Town & Country Planning Act 1990 (as amended)
Town and Country Planning (Development Management Procedure) (England) Order 2015
Application for approval of details reserved by condition imposed under planning permission
BR/270/16/PL relating to condition No, 3 (surface water drainage), 4 (arboricultural protection
measures), 5 (construction site set up), 6 (materials of external walls and roofs), 7 (landscaping
scheme) & 10 (lighting)
Villa Maria Campbell Road, Bognor Regis,

Condition Number 4

Arun District Council have decided to **REFUSE details reserved by condition for the following reasons:**

Project:-			
Proposed Conversion Villa Maria Campbell Road Bognor Regis			
Title:-			
Proposed Tree Works			
Client:-			
SCG Properties Ltd			
Scale:-			
1:100 (@A1)			
Drawn By:-		Checked By:-	
PJD			
Date:-		Date:-	
18/07/17			
Job.No:-		Rev:-	
160035		24

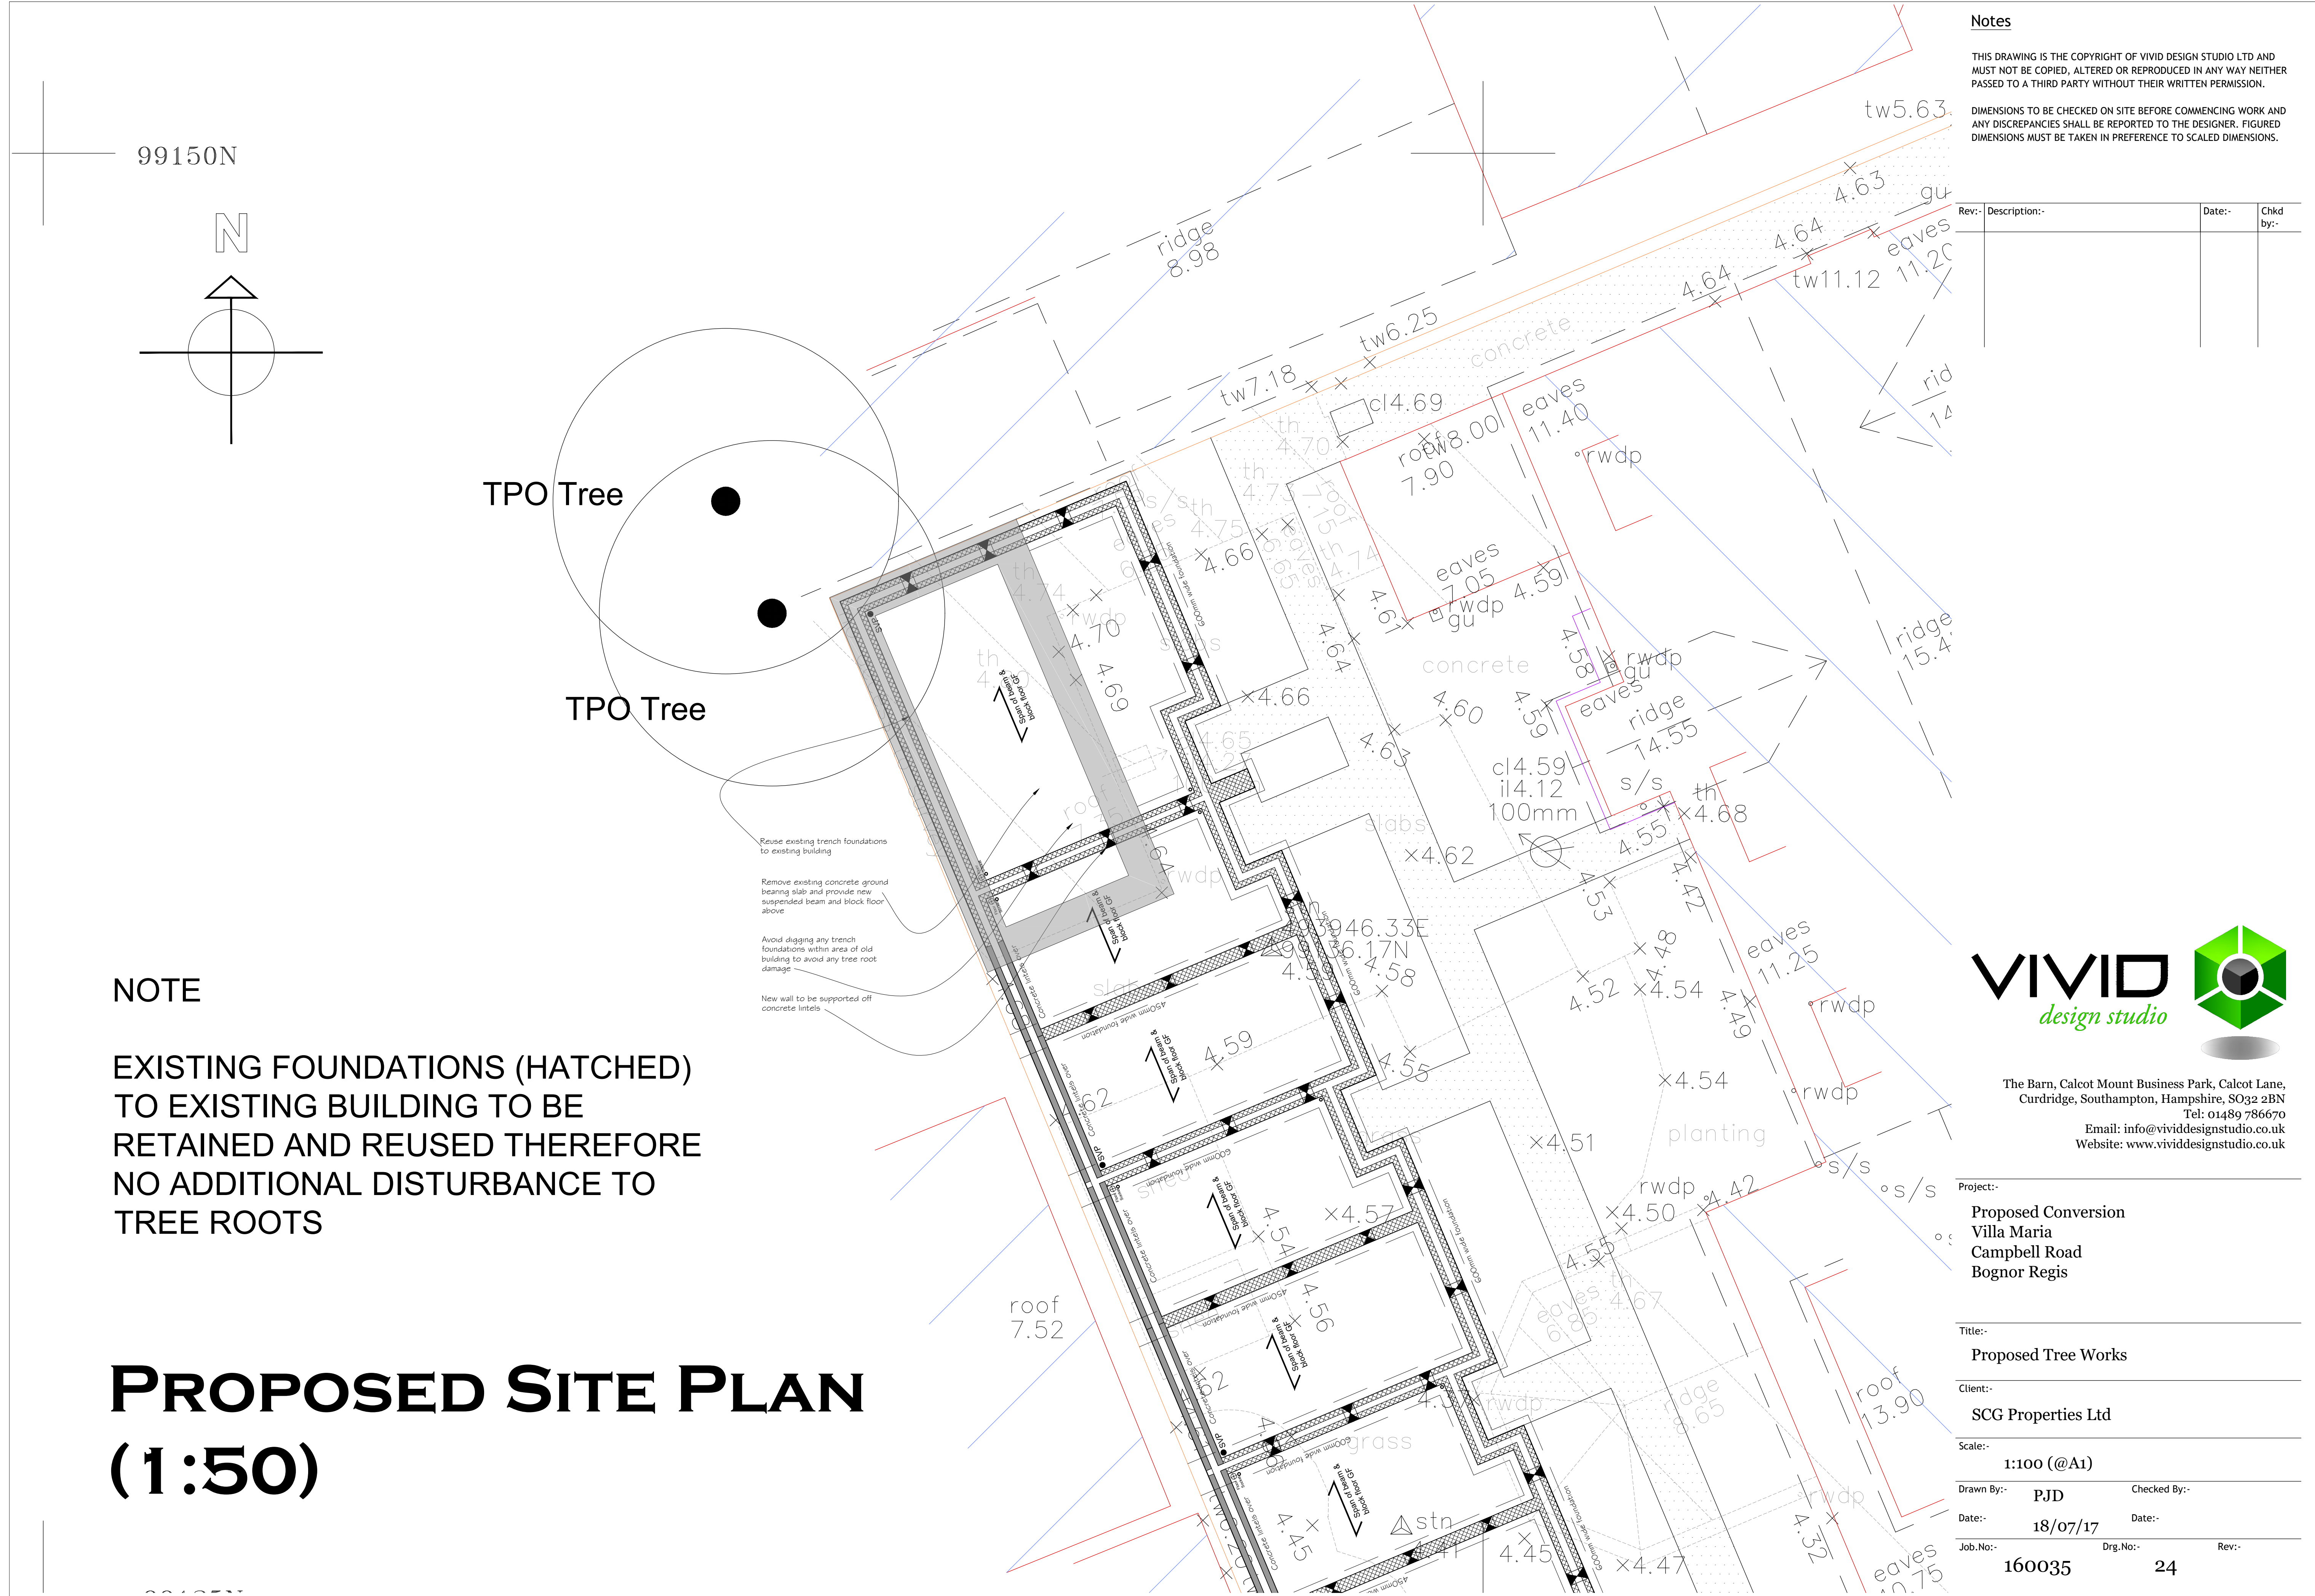
"The Proposed Site Plan received from VIVID design studio states that the existing foundations will be retained to protect tree roots - but I note that it also bears an annotation that the ground bearing floor slab will be removed and replaced - thus roots could be exposed and damaged in the process.

In order for me to be able to sign off on this Condition I will need to see a mini method statement report submitted from a Consultant Tree Expert stating how this will be carried out without damaging any tree roots + details of their intentions to be there when the slab is removed to satisfy the monitoring & supervision aspect of this Condition + a written report submitted with photographs to show that no harm came to tree roots."
